ENG-CDR20001-V6-GEC1B Summary_Markup Summary

CDR-20-00
PPR-19-009

### TYPICAL SECTIONS & DESIGN DATA - INEHURST CIRCLE

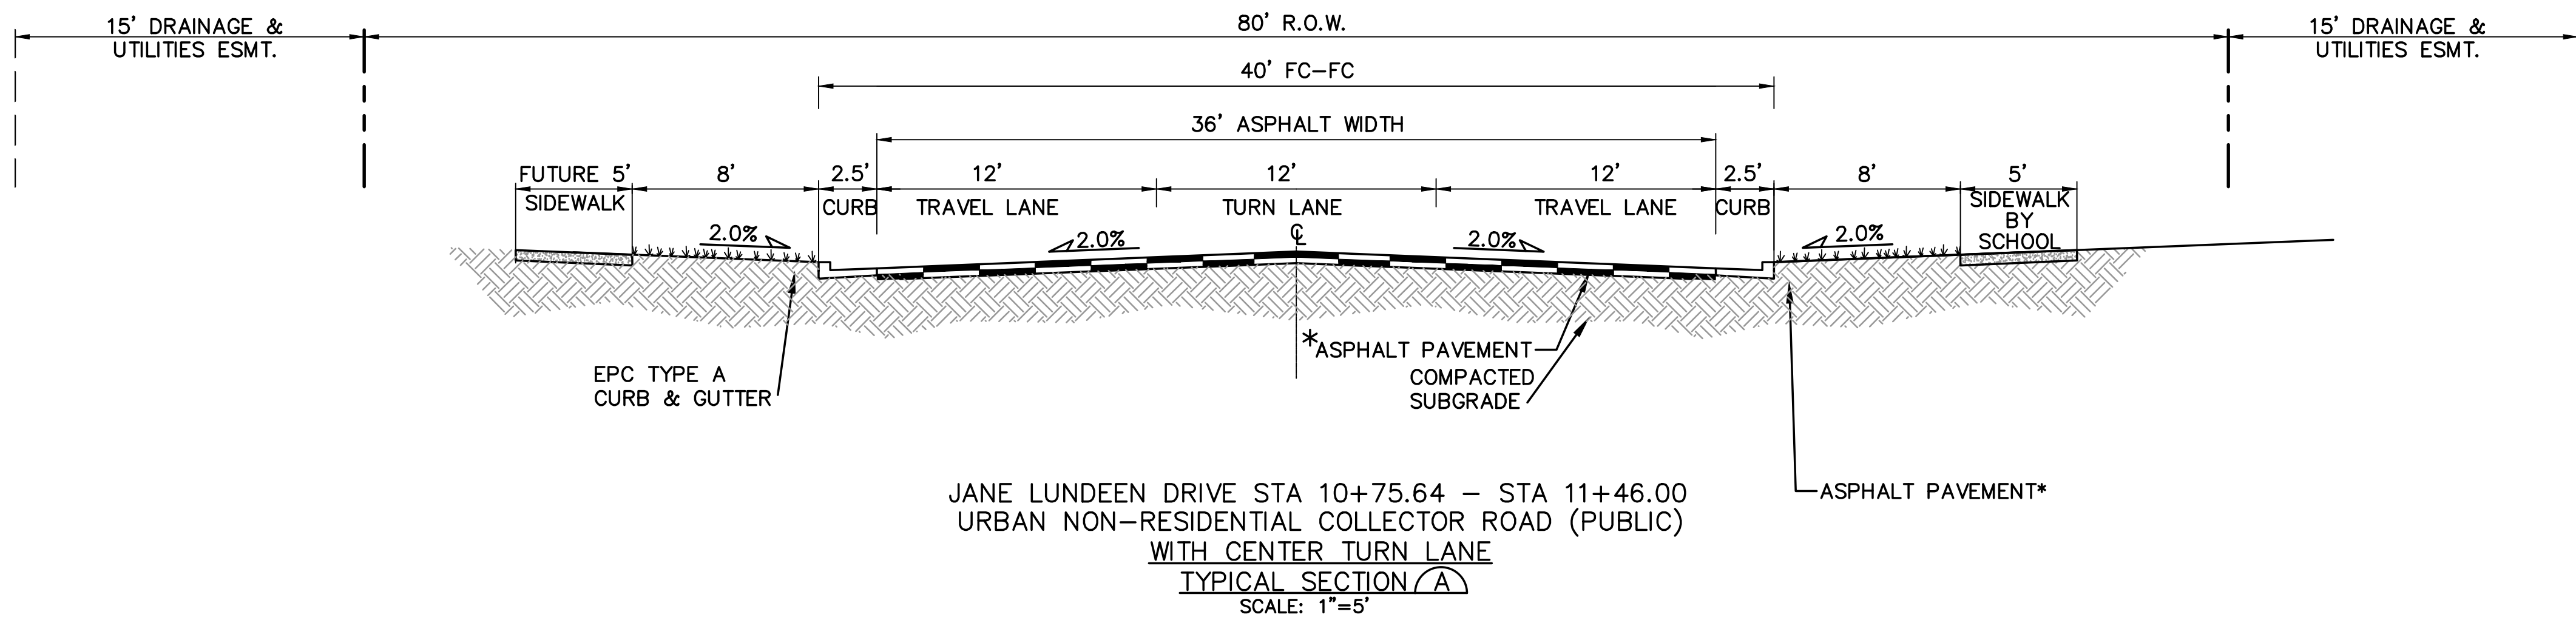
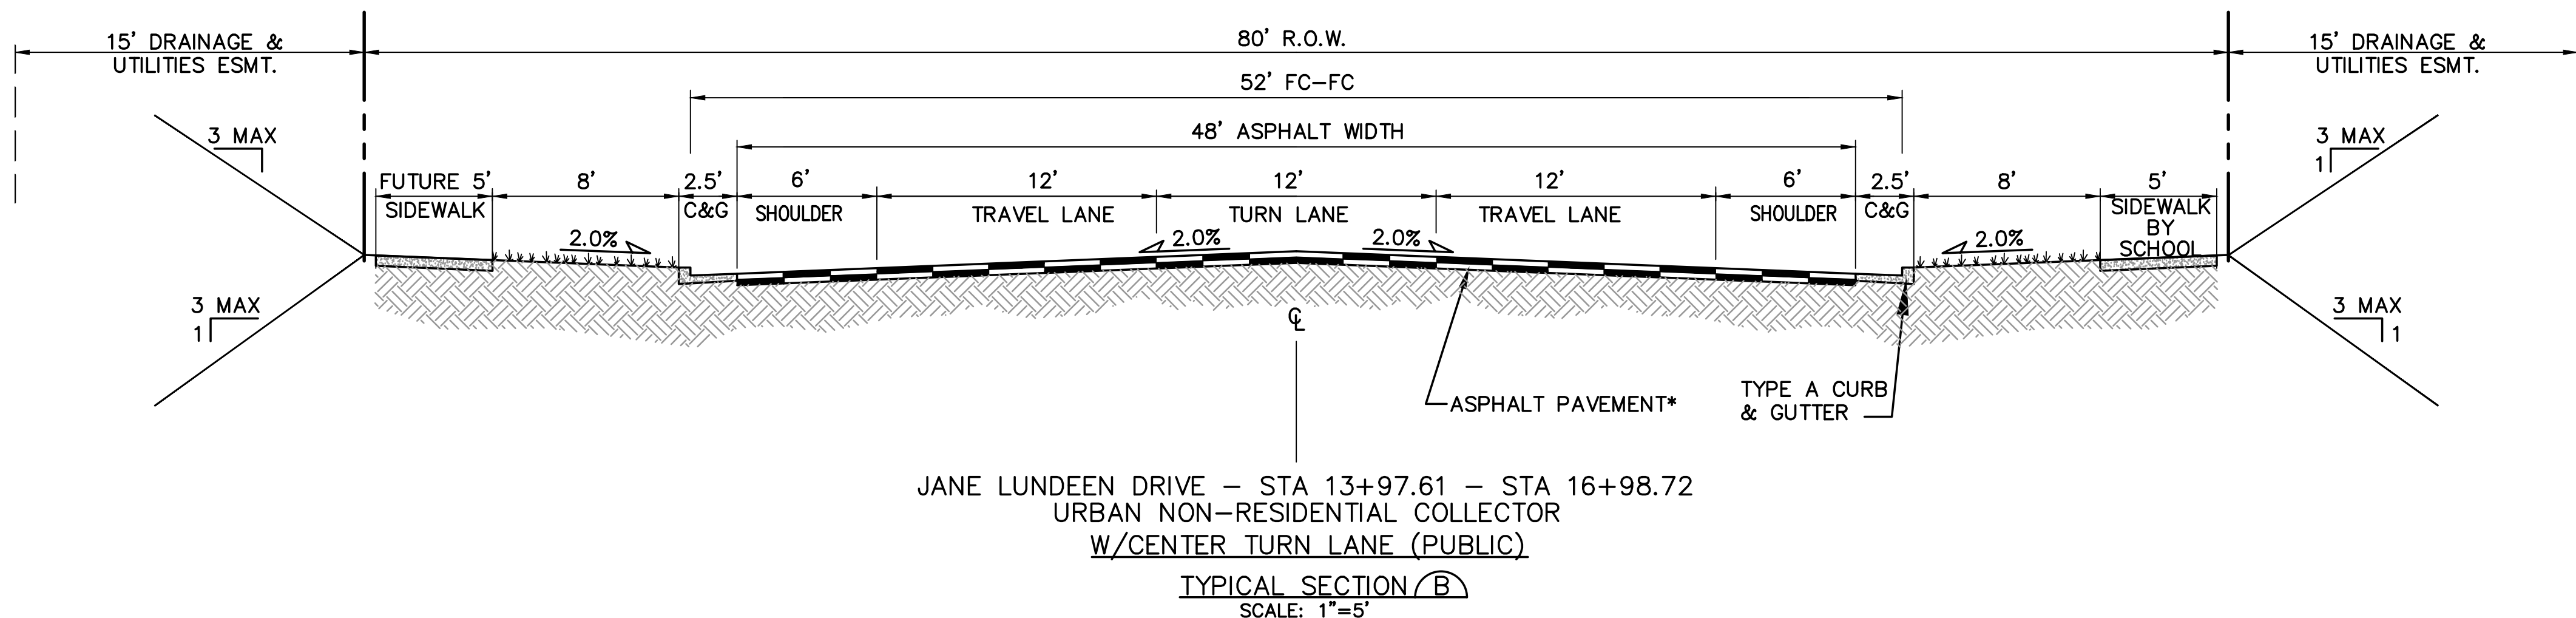
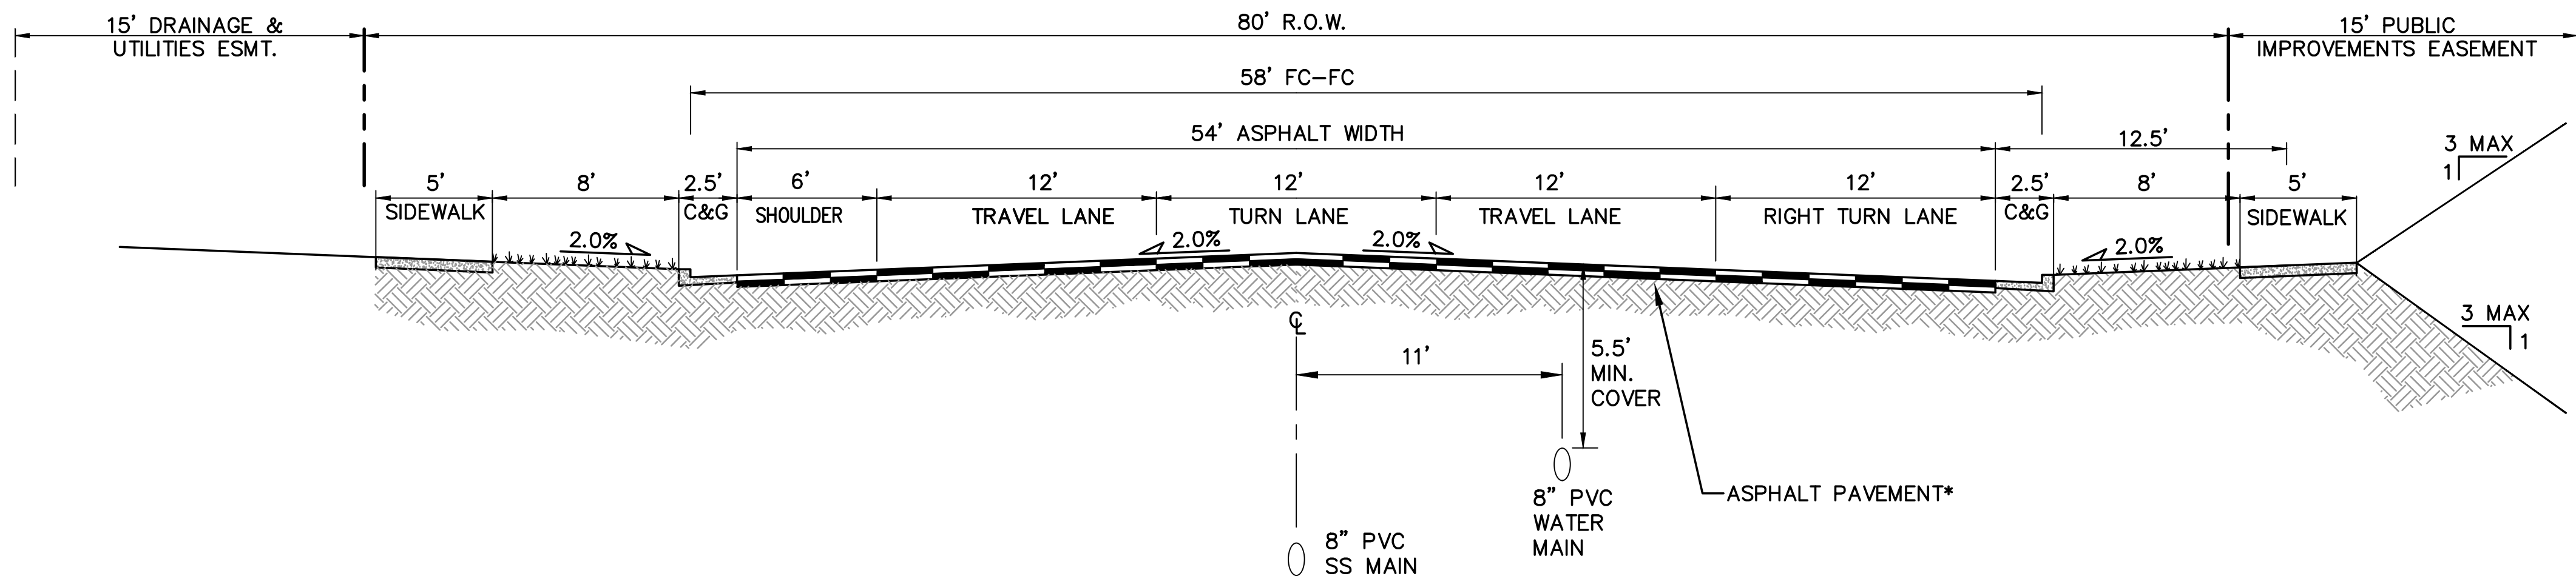
Provide updated geotech report for road construction.

HW2.1

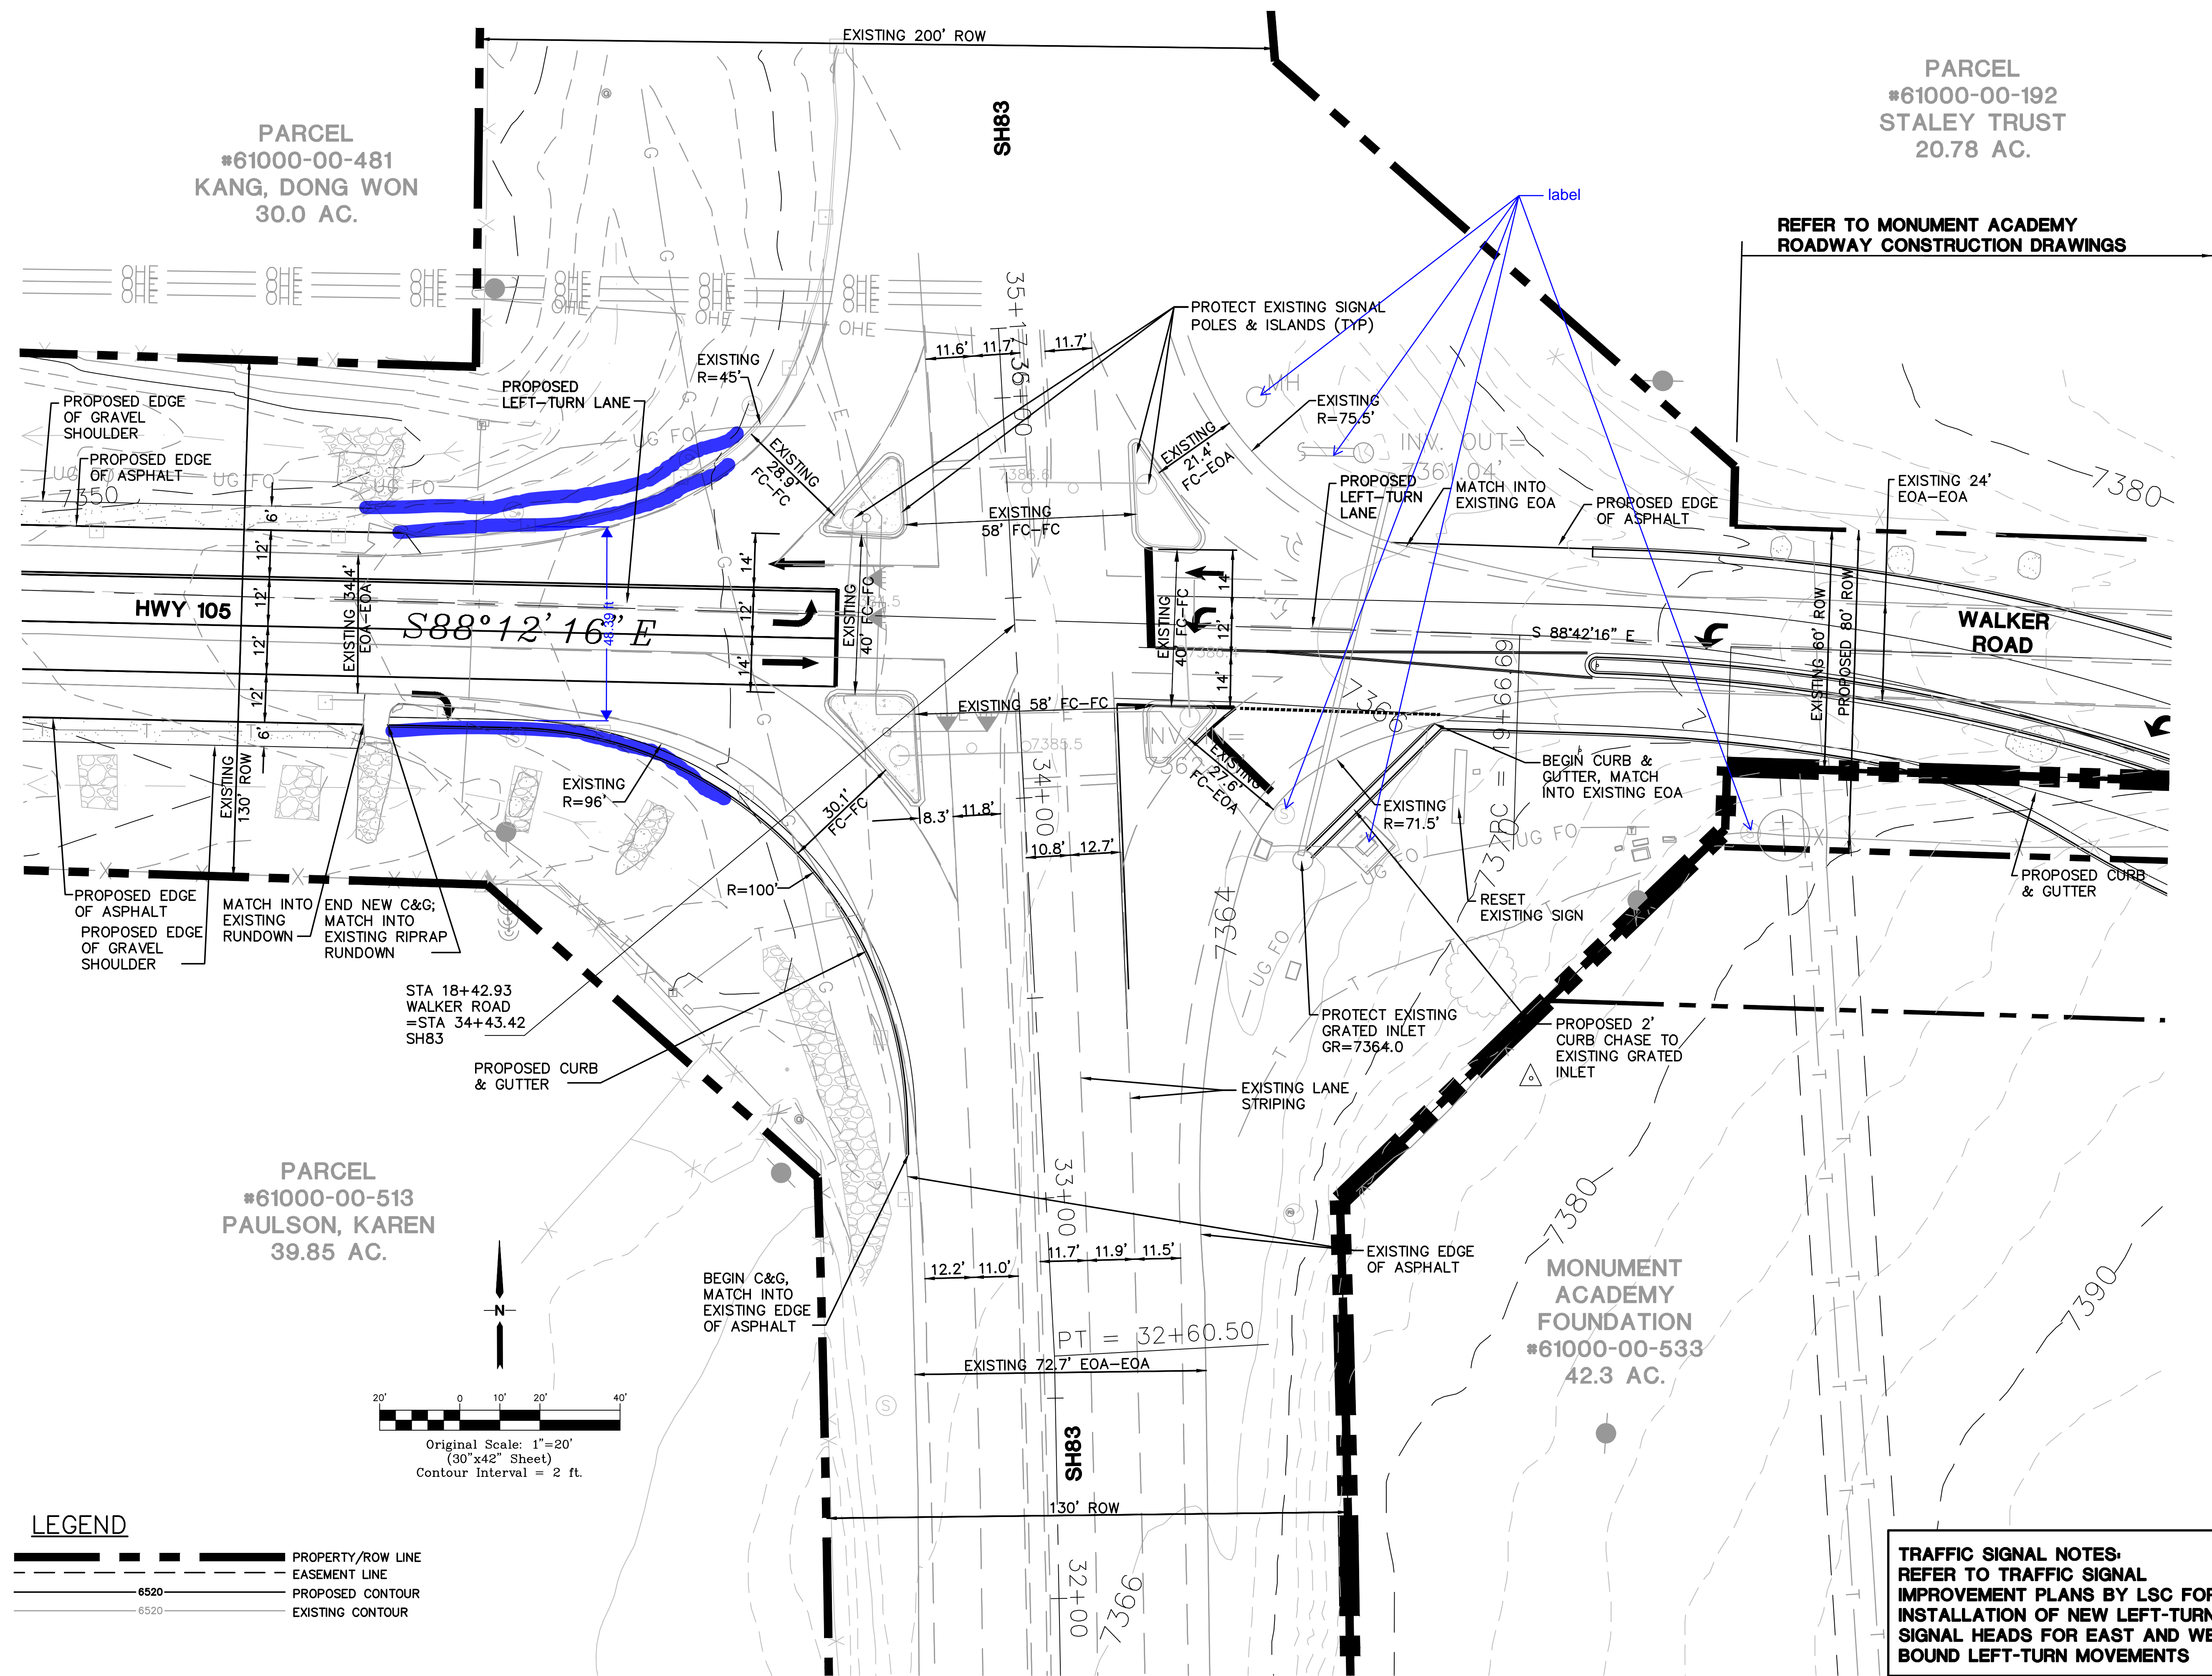
Lane width is 15', not 18'

Show the curb radius or 3-centered compound curve. Check turning template for WB67 (especially NW and SE corners).
